Addendum No. 1

RE: Contract # C204737

Moore County (U-5815BA)

SR-2055 (N POPLAR ST) FROM ELM ST IN ABERDEEN TO 500' NORTH OF BLUES CROSSING LN IN SOUTHERN PINES

PROJECT REFERENCE NO.	SHEET NO.
U-5815BA	UC-13
DESIGNED BY: NLH	
DRAWN BY: JNB	
CHECKED BY: CPM	
APPROVED BY: NLH	
REVISED:	UTILITY CONSTRUCTION PLANS ONLY
NORTH CAROLINA DEPARTMENT OF TRANSPORTATION UTILITIES ENGINEERING SEC. PHONE: (919) 707-6690 FAX: (919) 250-4151

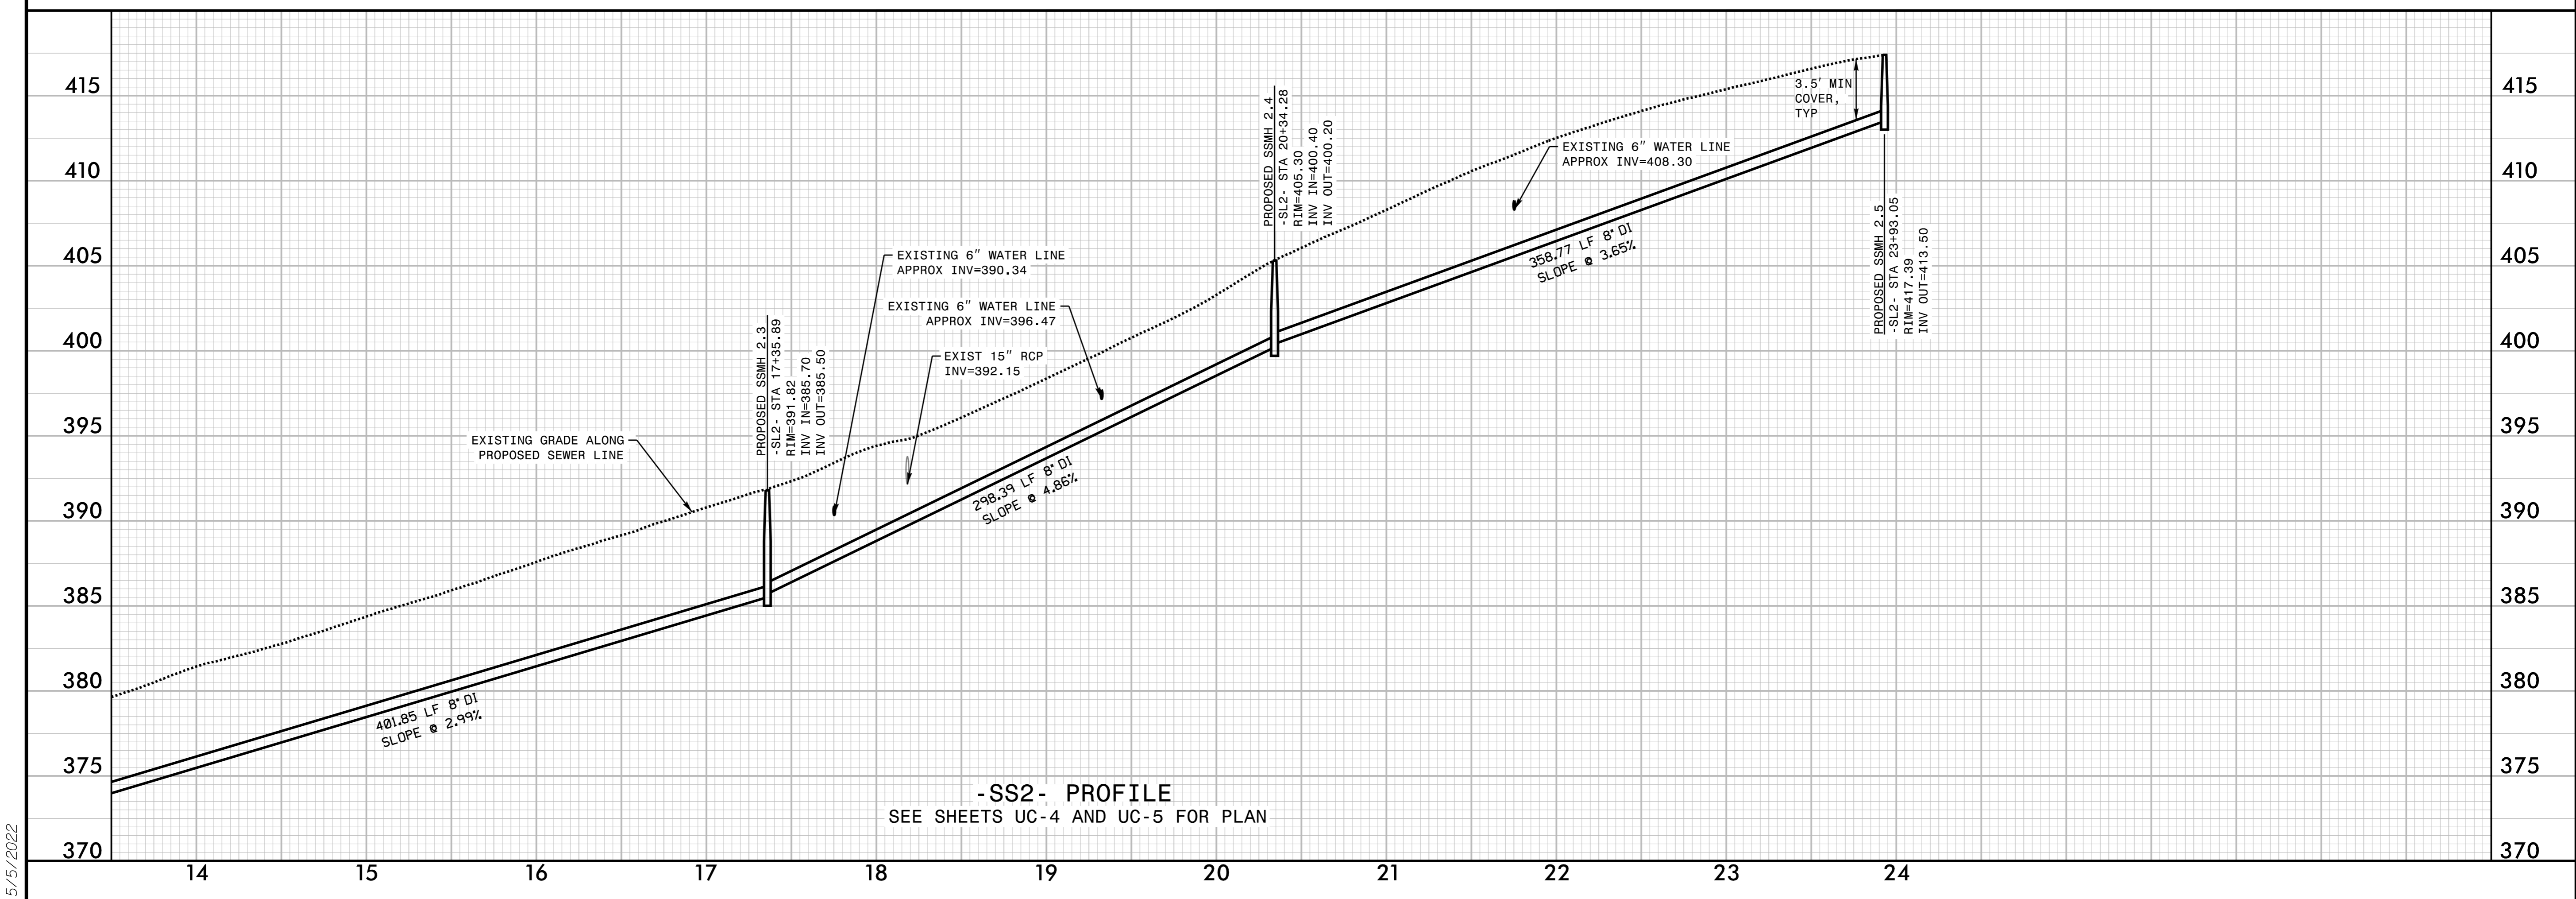
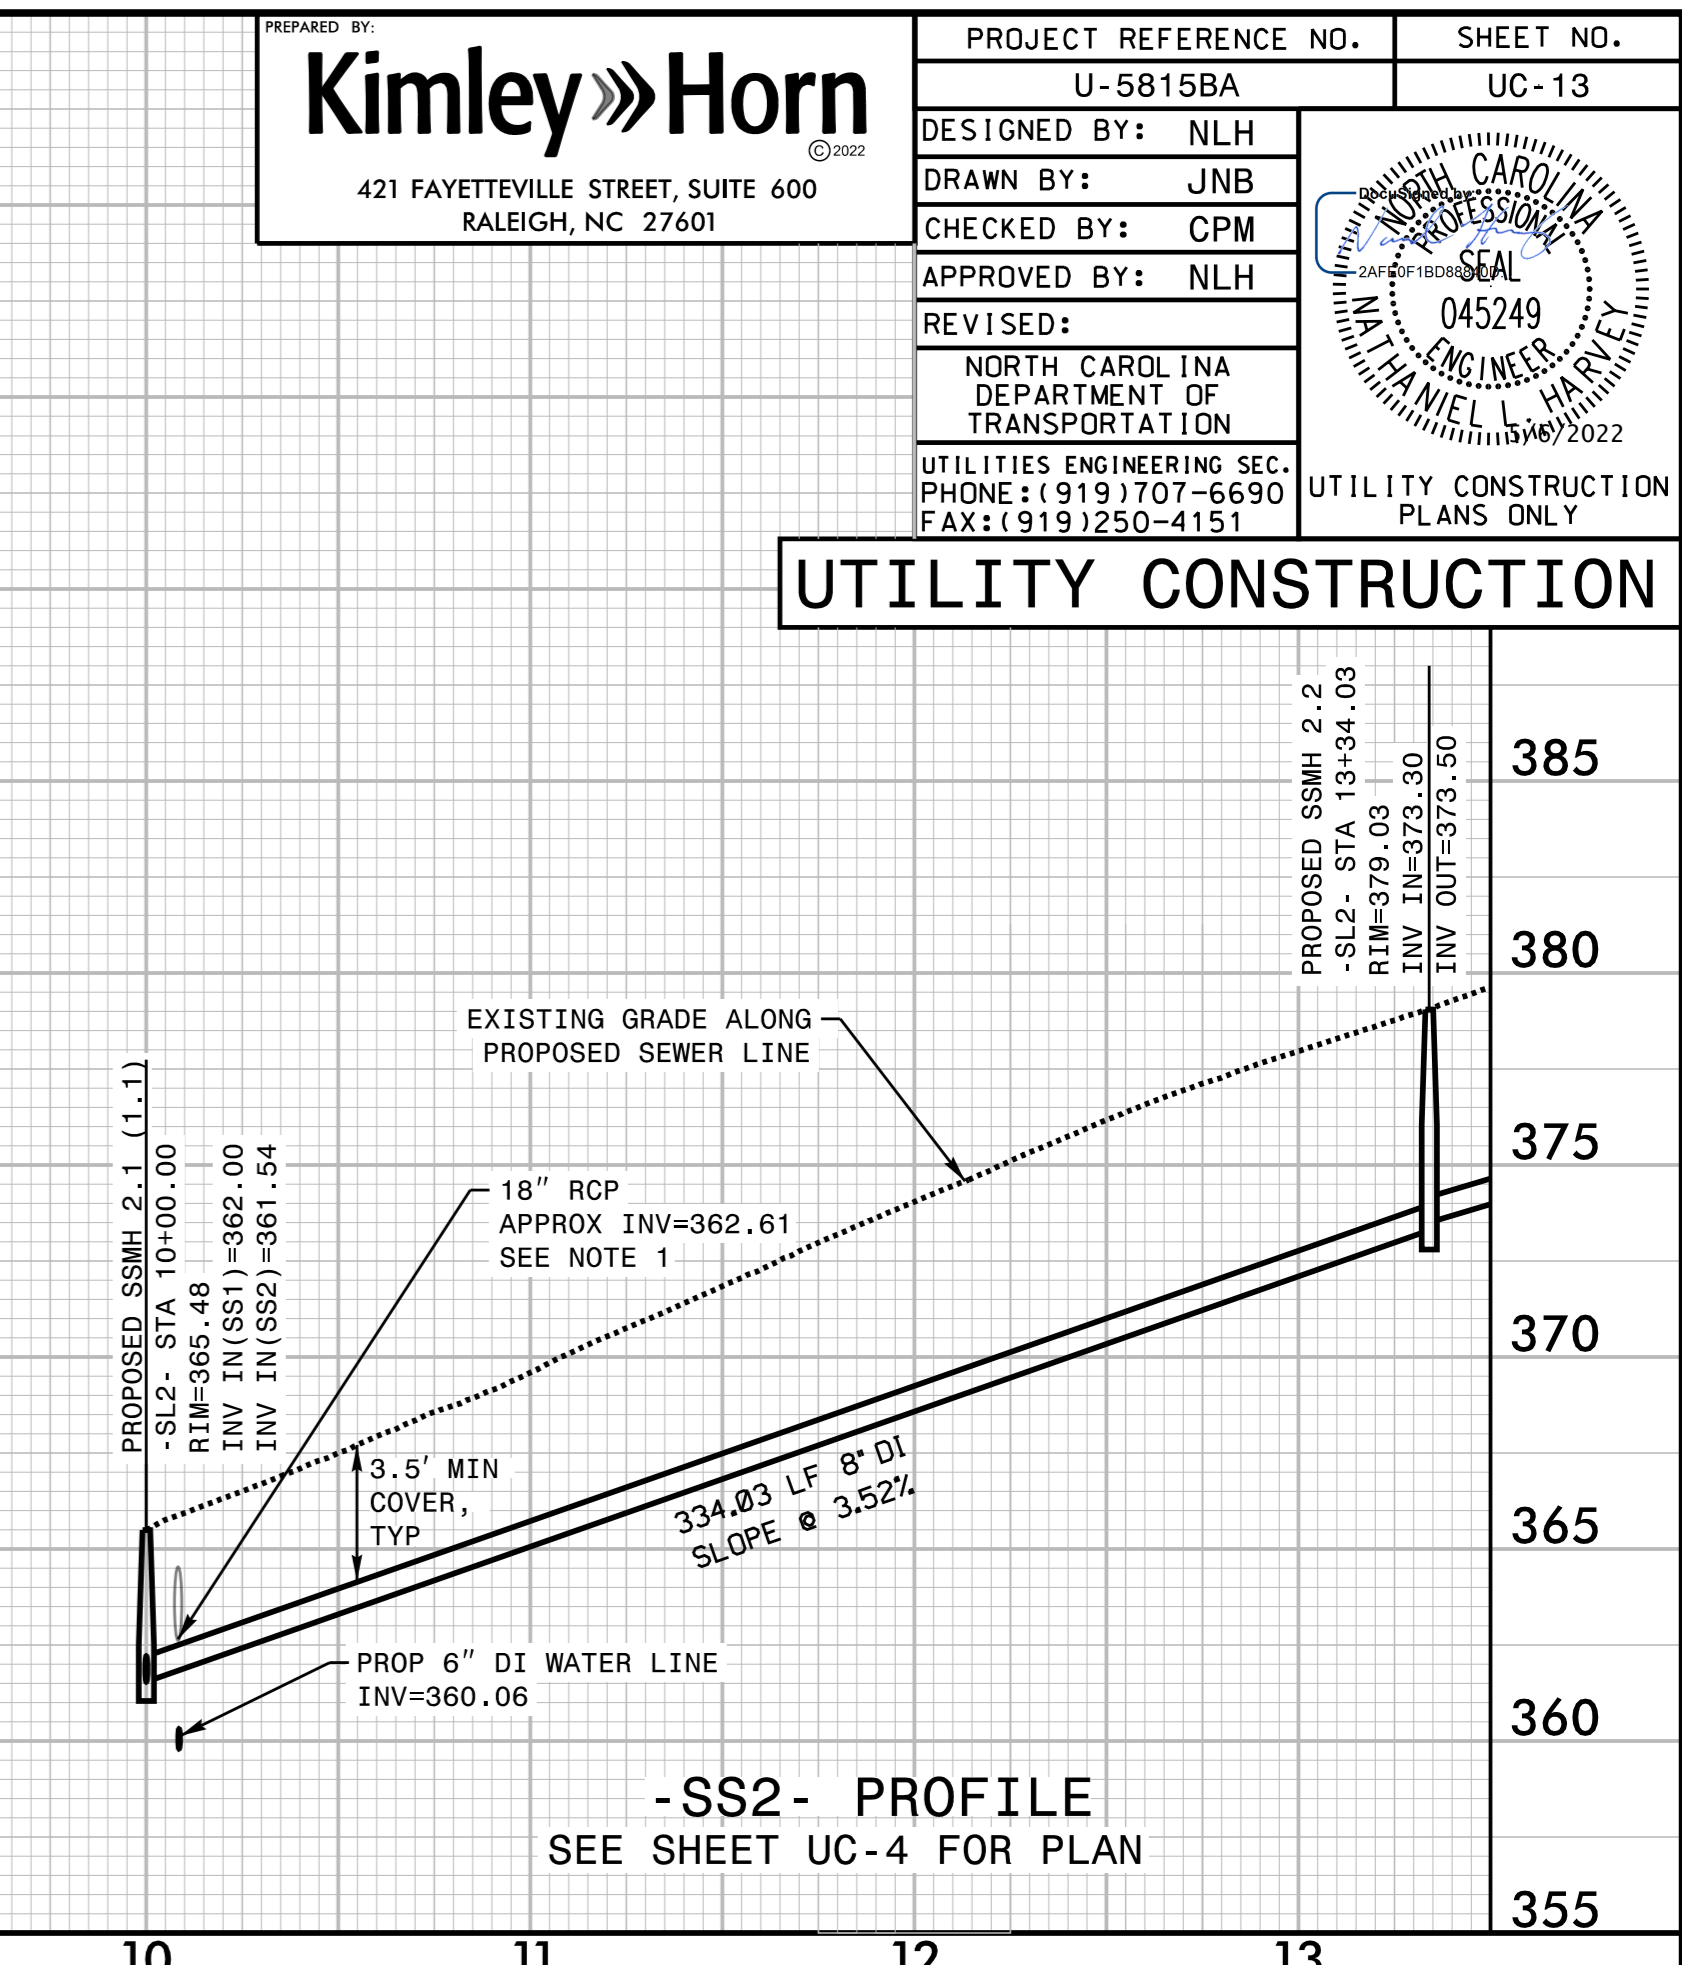
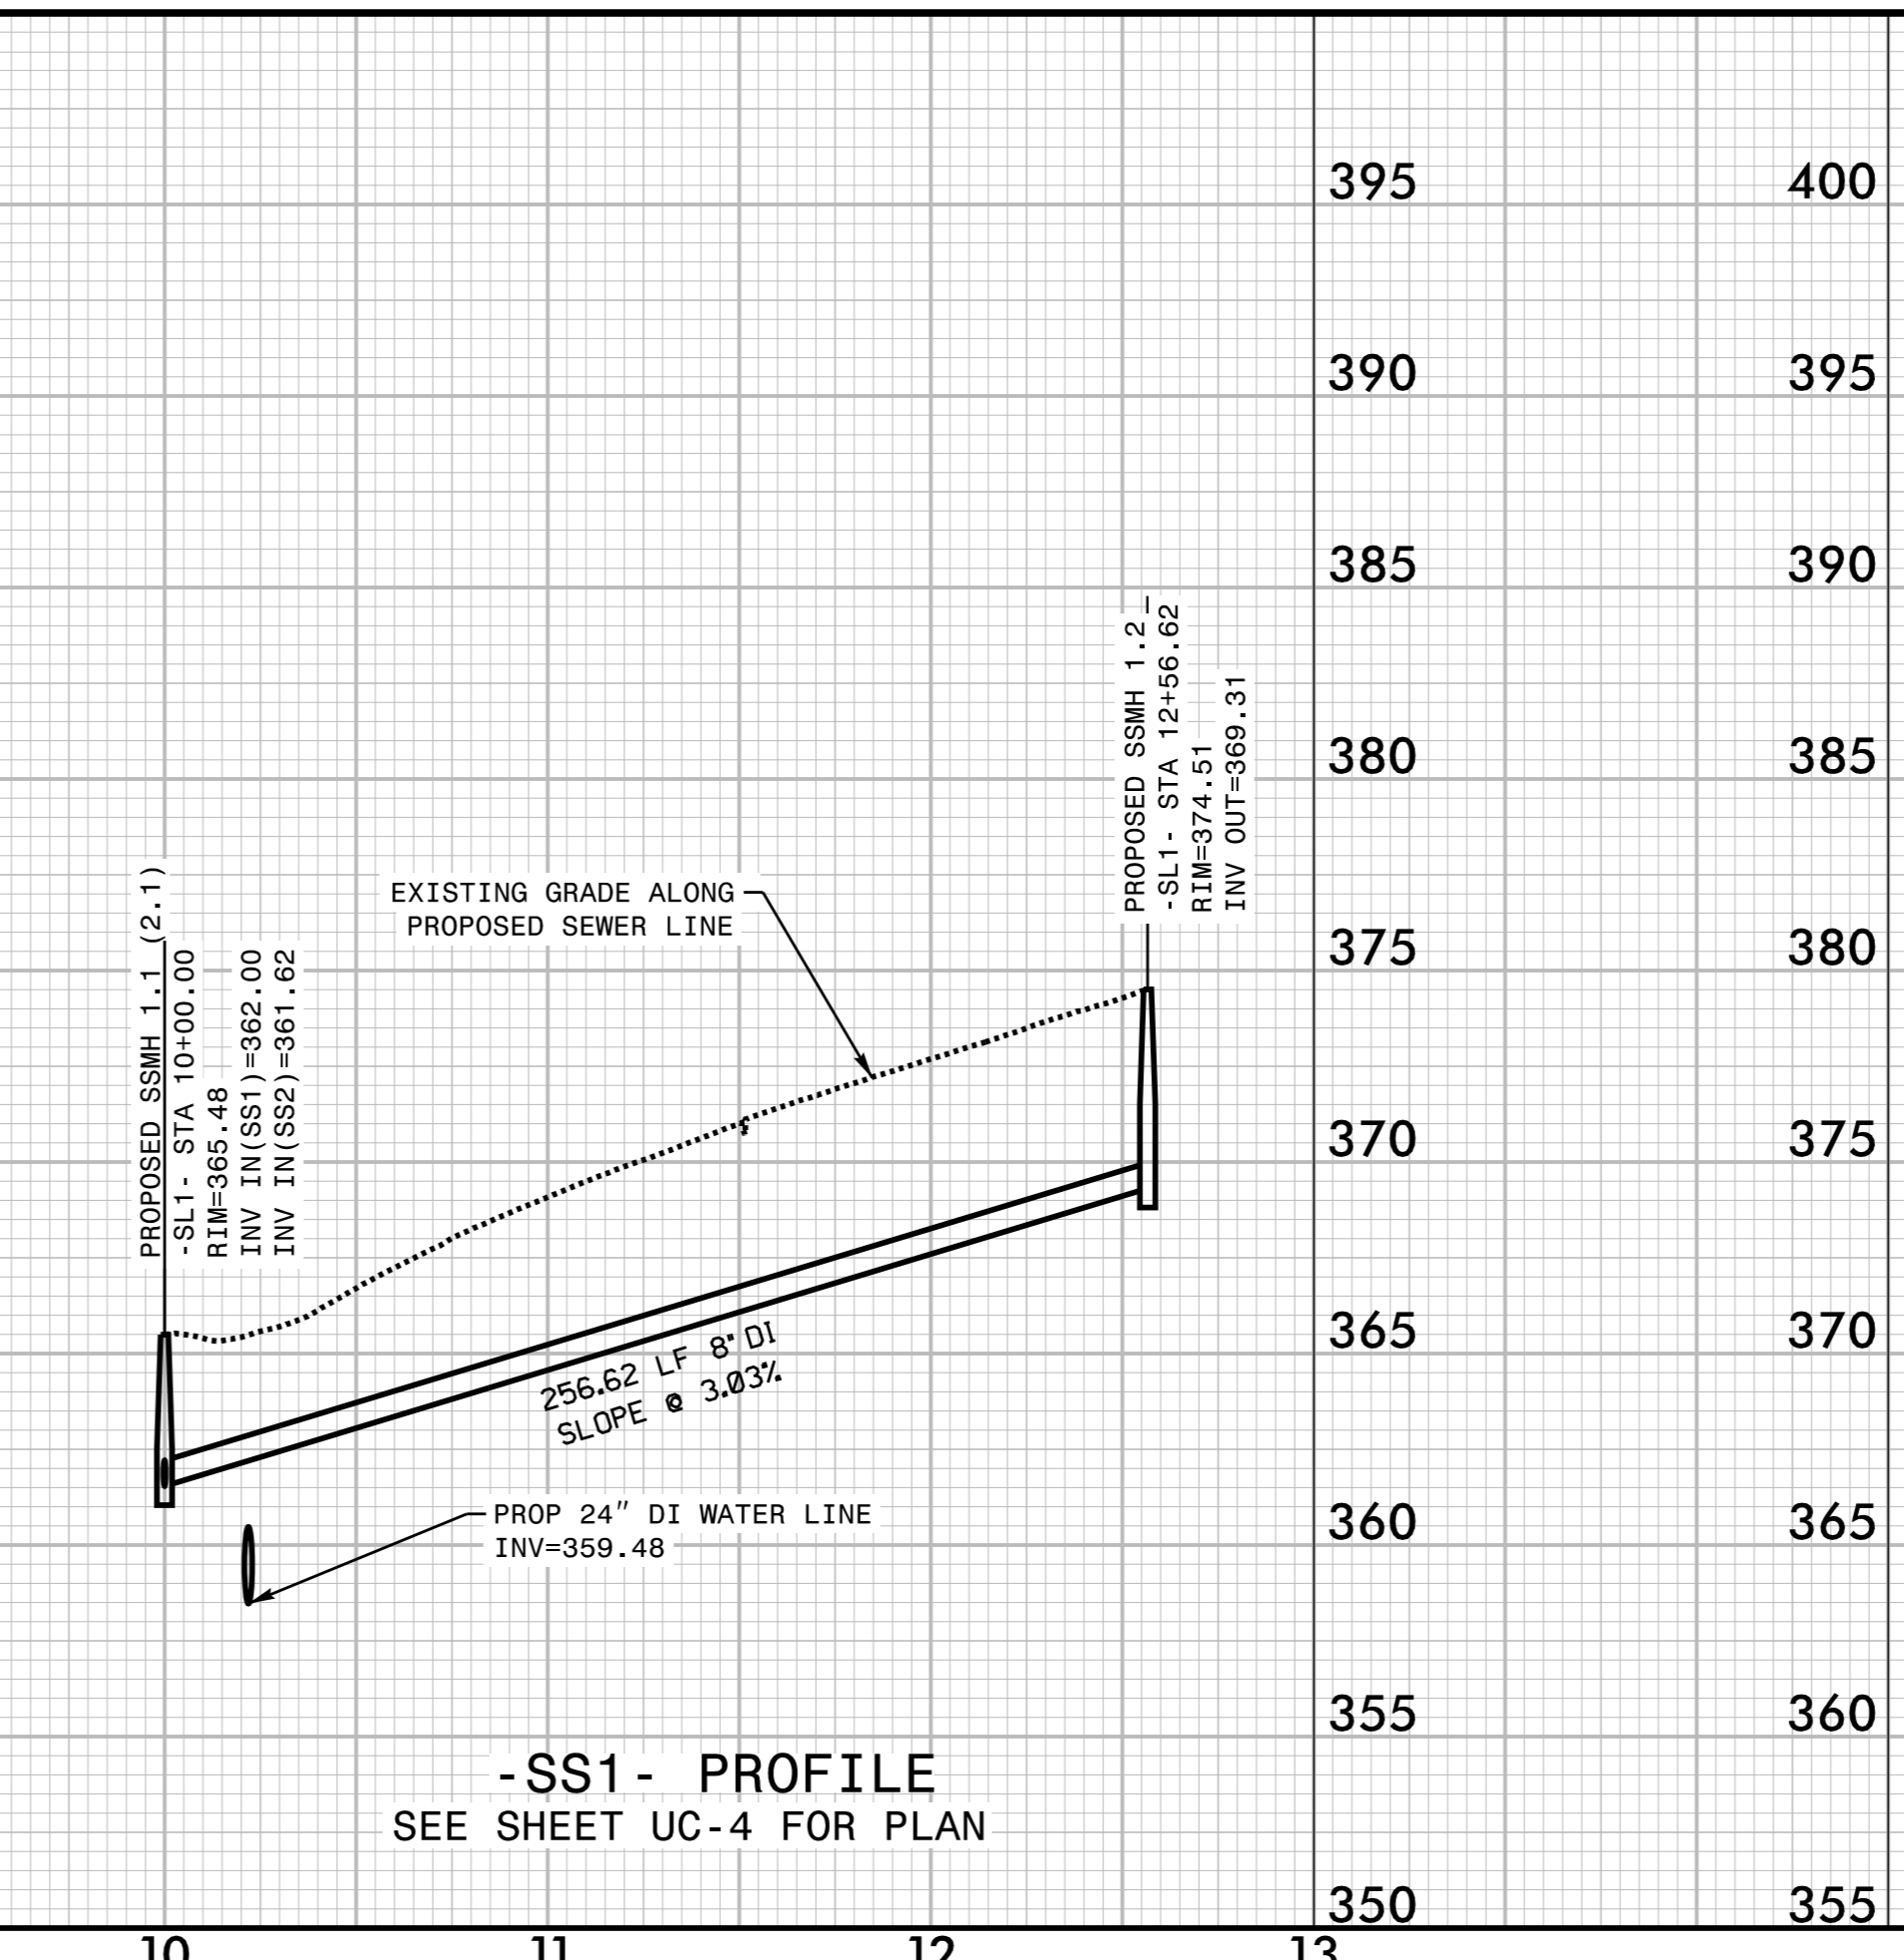
Sheet No.	Revision
UC-10 to UC-13	Revised vertical location of crossing gas lines shown on water line profiles based on test holes. Minor vertical adjustments to water line profiles to avoid conflicts with gas lines.
